Application for a non-material amendment following a grant of planning permission, Town and Country Planning Act 1990

Non material amendment to previous permission 2012/93779 for erection of single and 2 storey extensions

15, Hermitage Park, Fenay Bridge, Huddersfield, HD8 0JU

Application Number: 2017/94222

Job Number	Drawing Number	Revision
75/2012	03	A

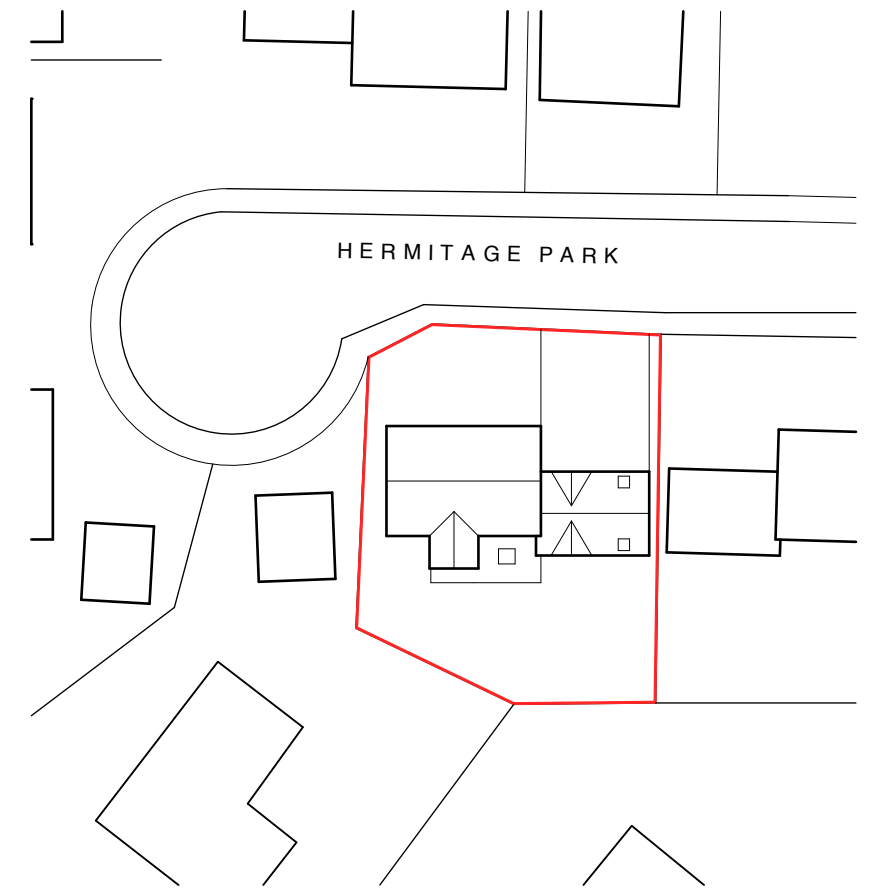
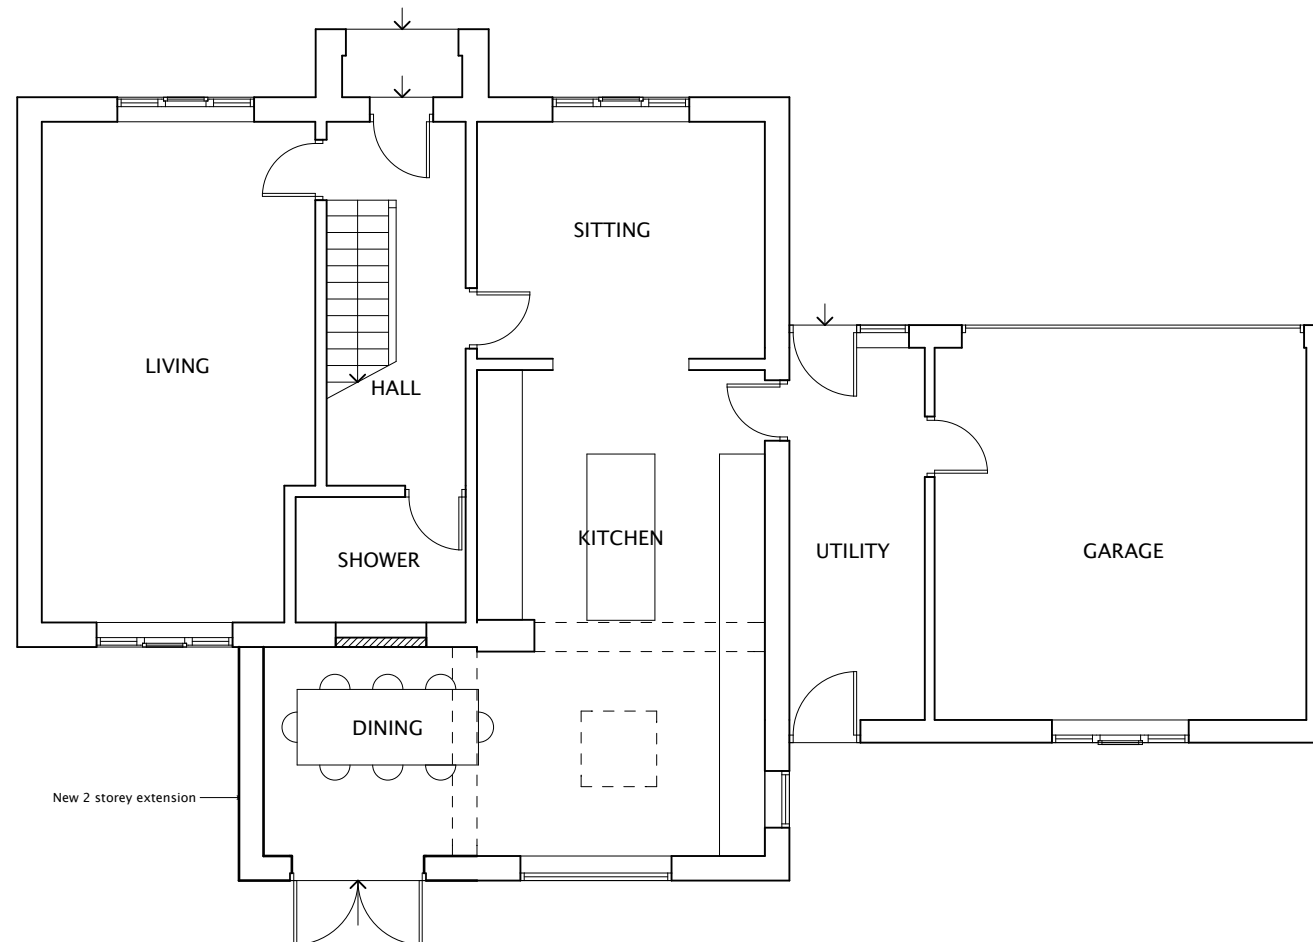
Thank you for your application dated 09-Dec-2017 for a non-material amendment to the above scheme. The amendment sought relates specifically to the first floor extension above the garage and the alteration to the ridge line of the roof and the removal of the front dormer to the front/east elevation as shown on drawing number 75/2012 – 04A.

I confirm that the alterations are acceptable and may be considered as a non-material amendment to the approved drawings. It should be noted that this letter relates only to the non-material amendment sought and it is not a re-issue of the original planning permission. The two documents should be read together and as such, all conditions imposed on the original granting of planning permission apply to the proposal as now amended. A copy of this letter and the amended plans will be retained on the public record of approved documents.
